PLANNING CONSULTATION RESPONSE

Application No	2025/0867
Proposal	Erection of outbuilding (retrospective) to be used for golf simulator business.
Address	5 Willow Bank, Barnsley, S75 1BN
Date of Consultation Reply	9 th December 2025
Consultee	Highways DC

[2nd Response]

With reference to the additional information and the amended plan Ref. 2025/29 CH02, I would comment as follows:

Ref. Dwg. No. Rev.  
**2025/29 CH02**

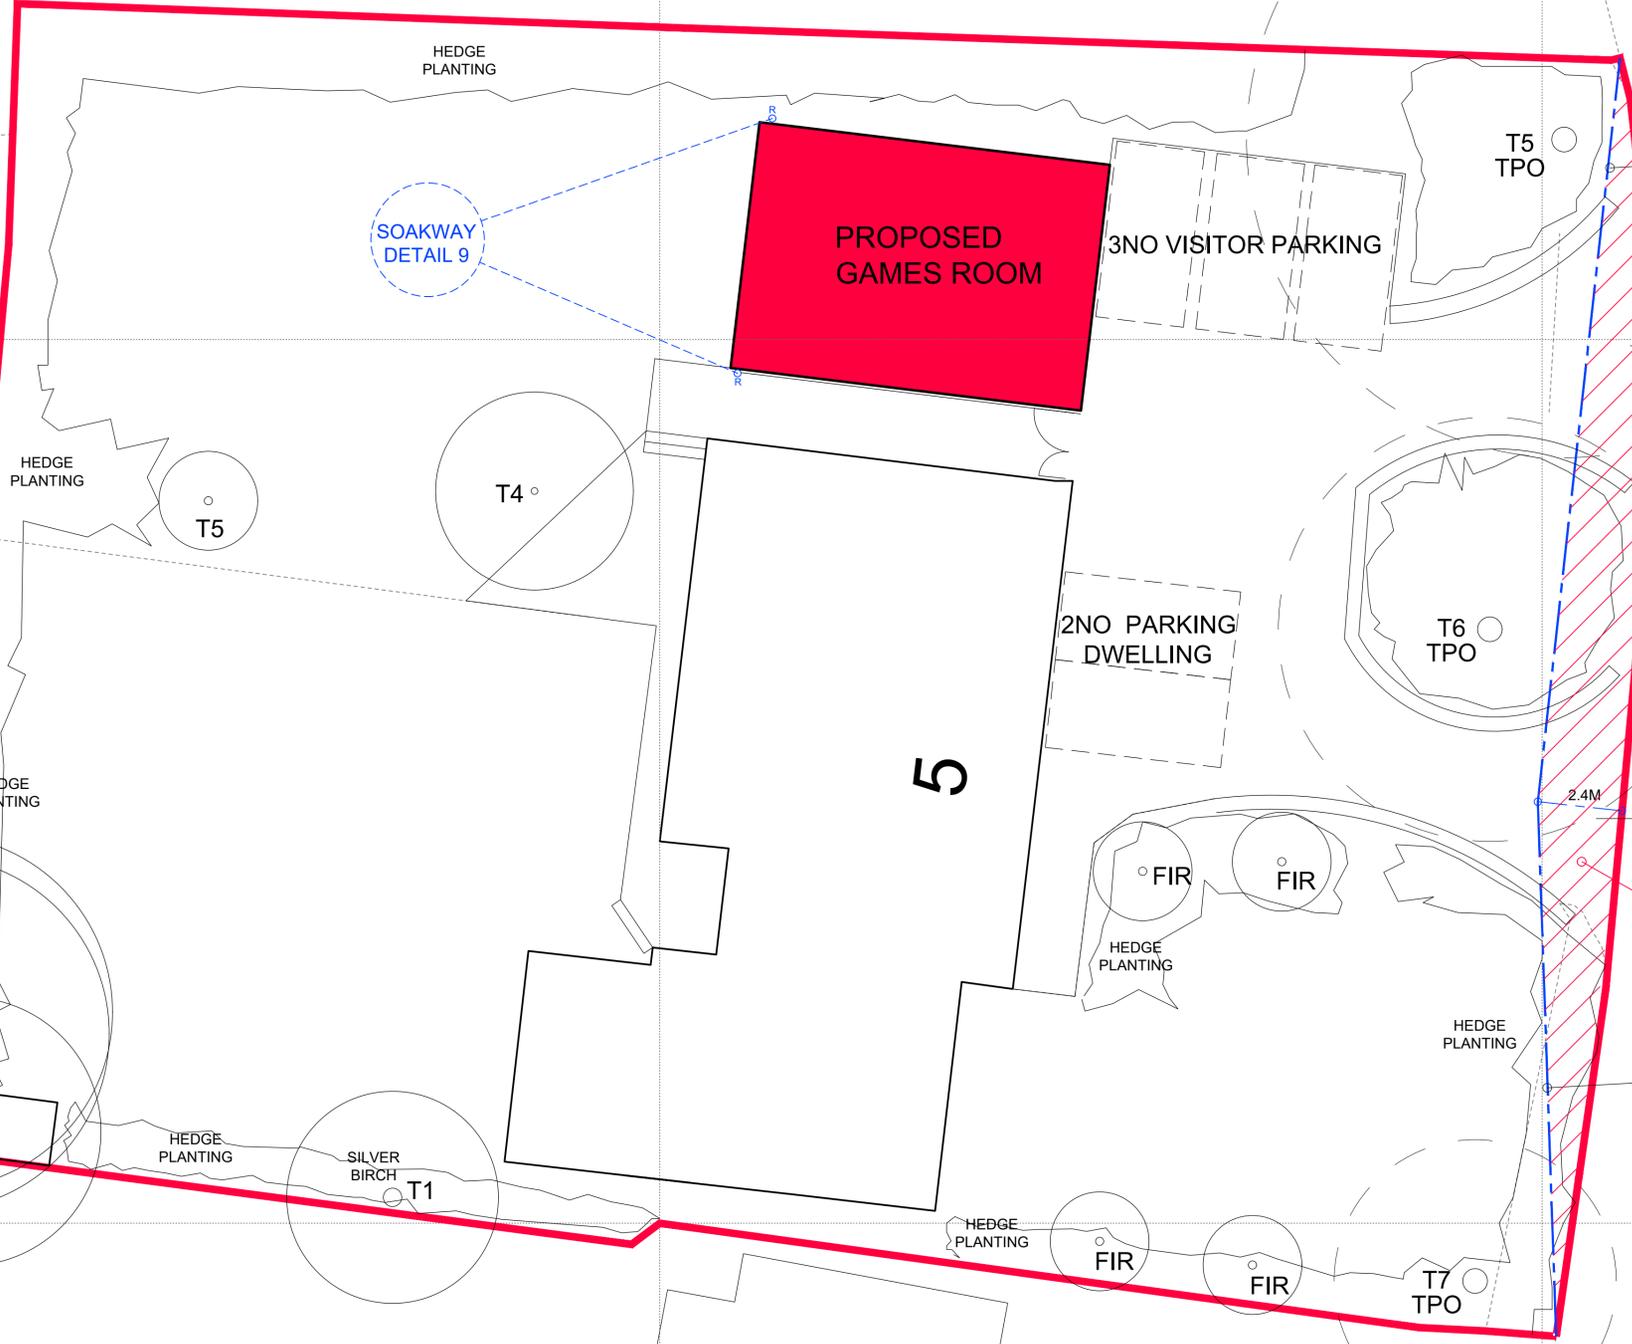
The site layout plan now shows that the required 5no. parking spaces can be satisfactorily accommodated within the site. The submitted details regarding the use of the site indicate that the golf simulator is already in use and is regularly attended by family and friends; the intention to operate the facility as a business is primarily seen as a formalisation of the existing arrangements and would not result in any discernible increase in vehicular movements.

Nevertheless, in order to mitigate against any potential intensification of use of the site, the proposals include significant improvements to the sight lines currently achievable from the site access points.

The parking/manoeuvring facilities, indicated on the submitted plan, shall be made available for the manoeuvring and parking of vehicles prior to the development being brought into use, and shall be retained for that sole purpose at all times.

The sight lines indicated on the submitted plan shall be provided at the access junctions with Willow Bank, such that there is no obstruction to visibility at a height exceeding 0.9m above the nearside edge of the adjacent highway. Nothing shall be erected, retained, planted and/or allowed to grow at or above a height of 0.9m which would obstruct the sight lines and they shall be maintained free of obstruction at all times thereafter for the lifetime of the development.
